Planning Application: **OUTLINE** planning application for 10 dwellings with access from Hoe Lane – resubmission from Y/40/17/OUT.

Reference: **Y/20/18/OUT**

Location: **Bonhams, Hoe Lane, Flansham**

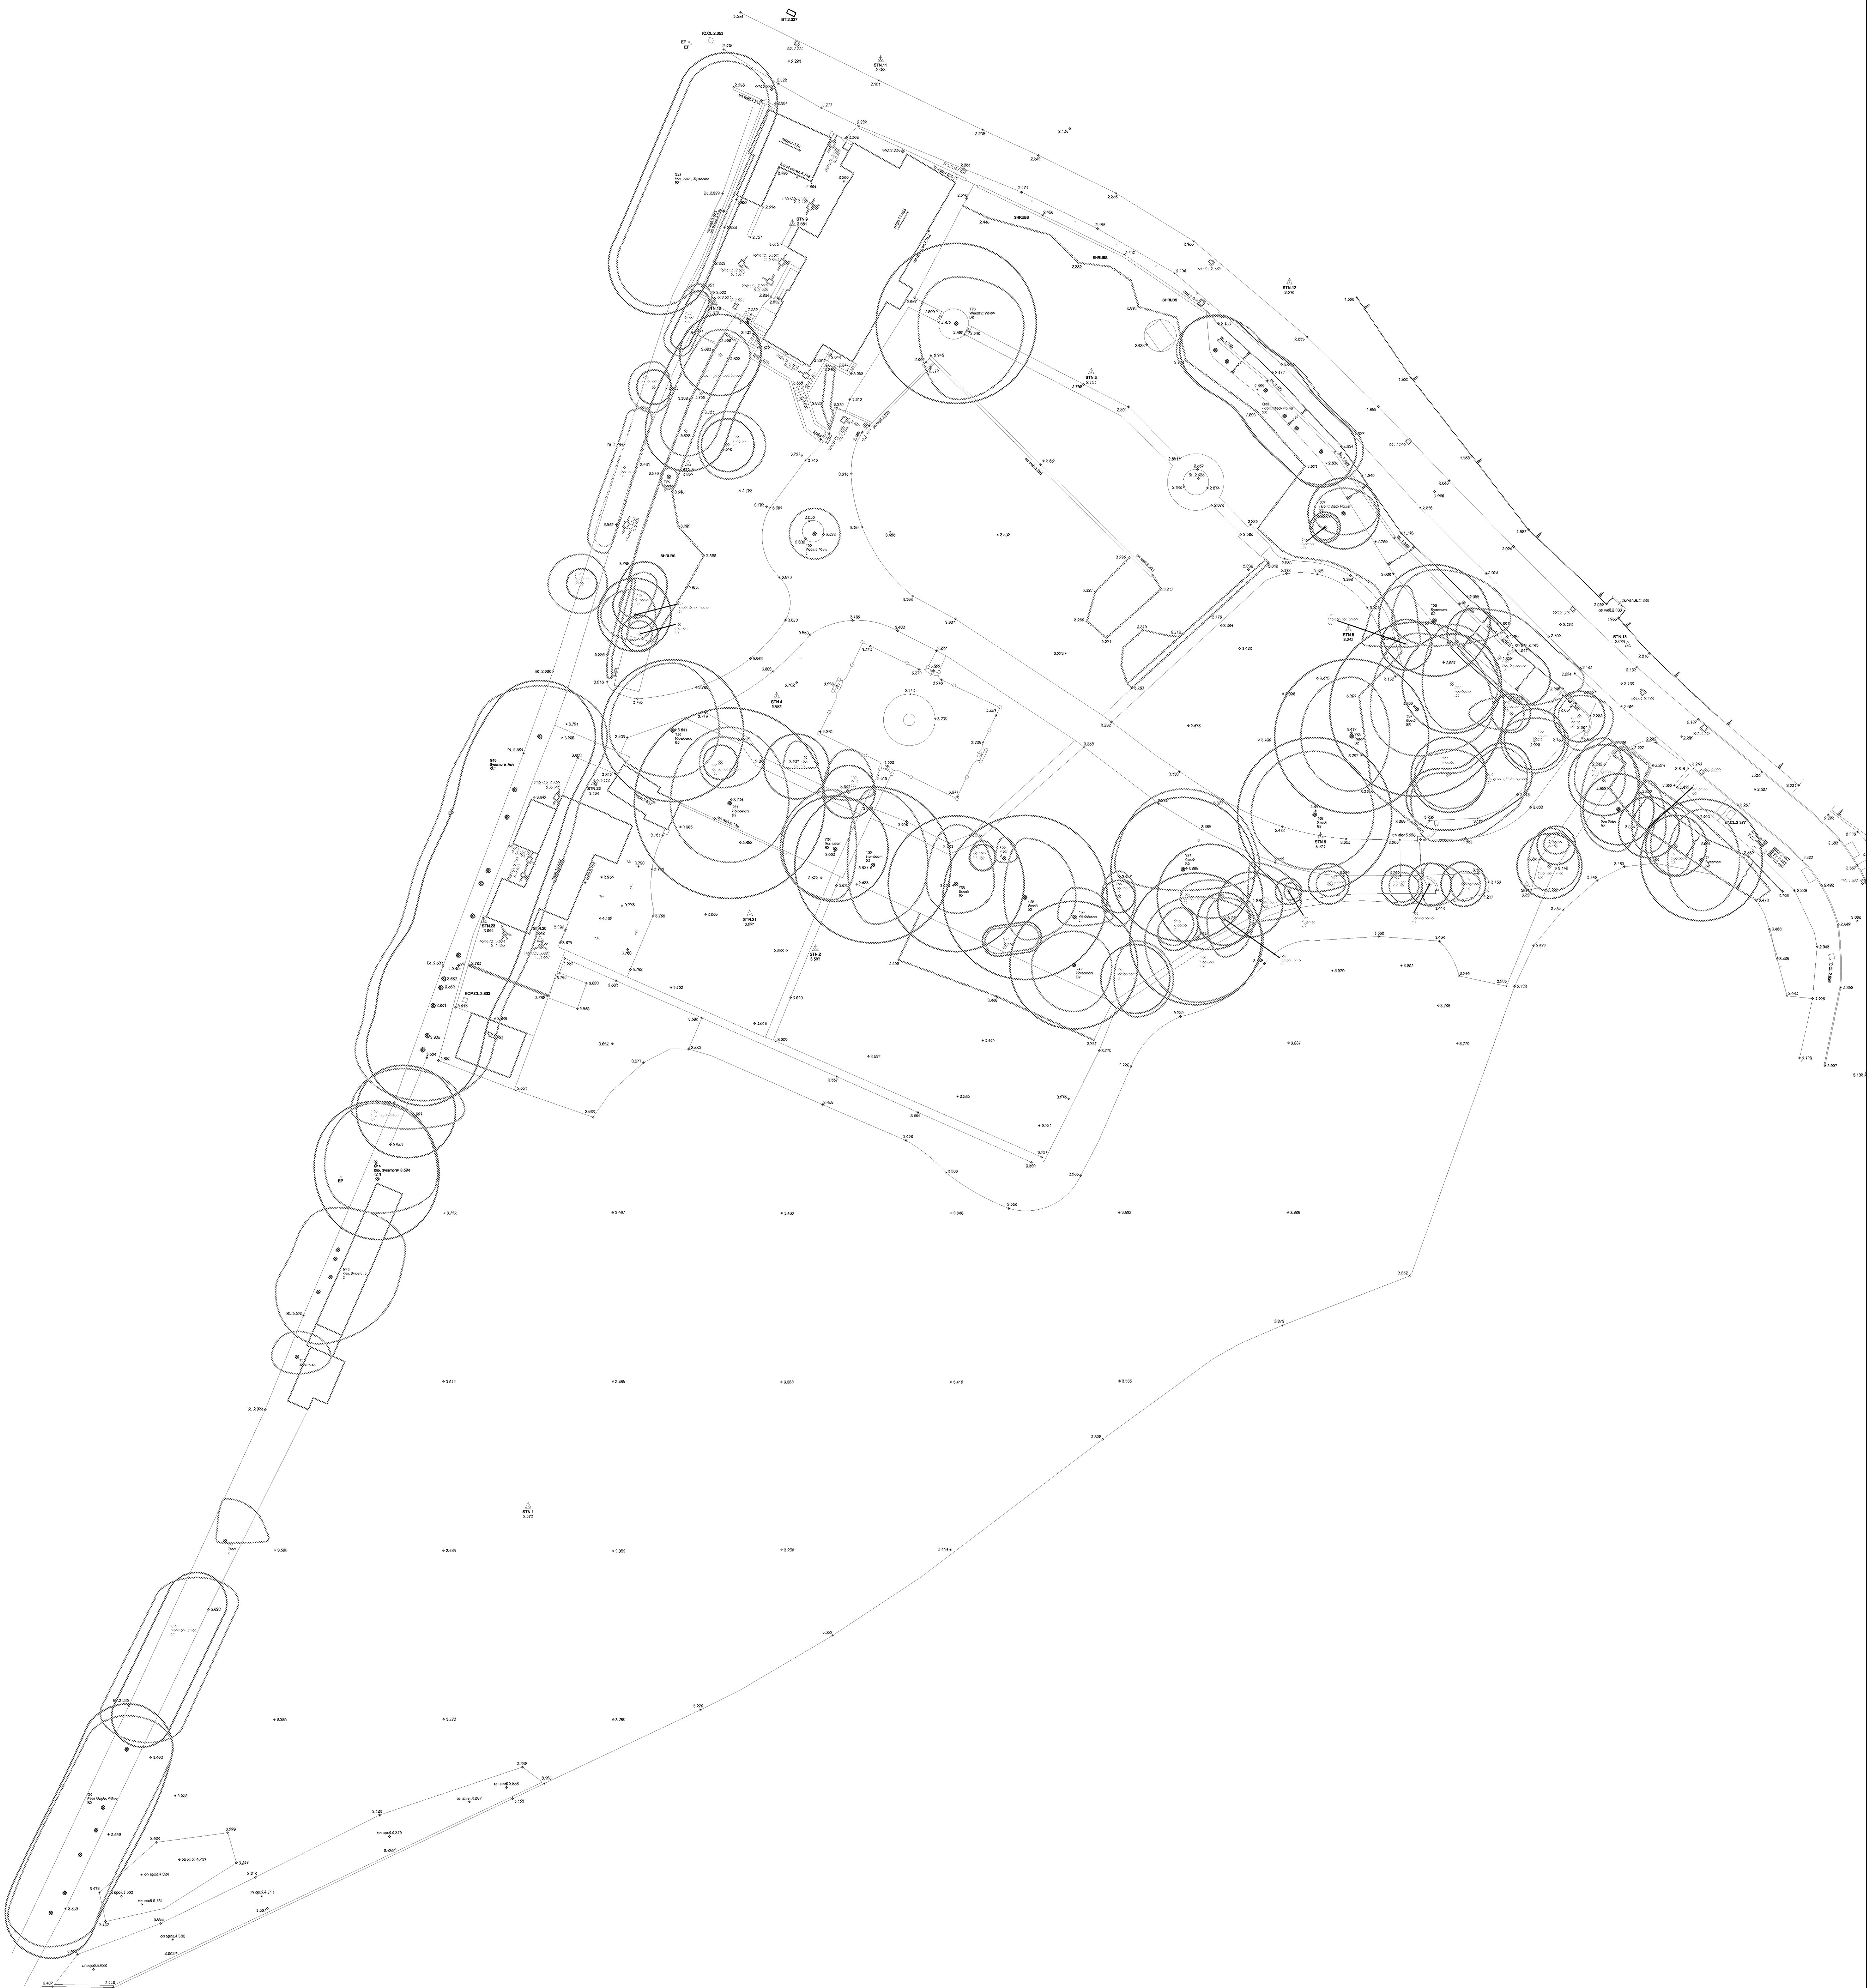
- The current layout shows 10 dwellings and in general these are set well back from any trees except for Grp 9 Field Maples in the bottom southeast corner where a garage block is placed very close to them and within their RPA. These are healthy trees which are highly prominent and important features in the landscape and should as such be fully respected.

- IF this site is developed as outlined on the draft plans then I would have only one real concern on tree grounds – the intrusion into the RPA of Grp 9 Field Maples and pressure to prune or fell which might ensue.

- I raise an **OBJECTION** to this scheme on the grounds that it threatens Grp 9 Field Maples – although if the scheme could be amended to accommodate the full RPA of these trees then I would be prepared to withdraw my objection.
- When this application comes back in for FULL planning it will need to be accompanied by :-
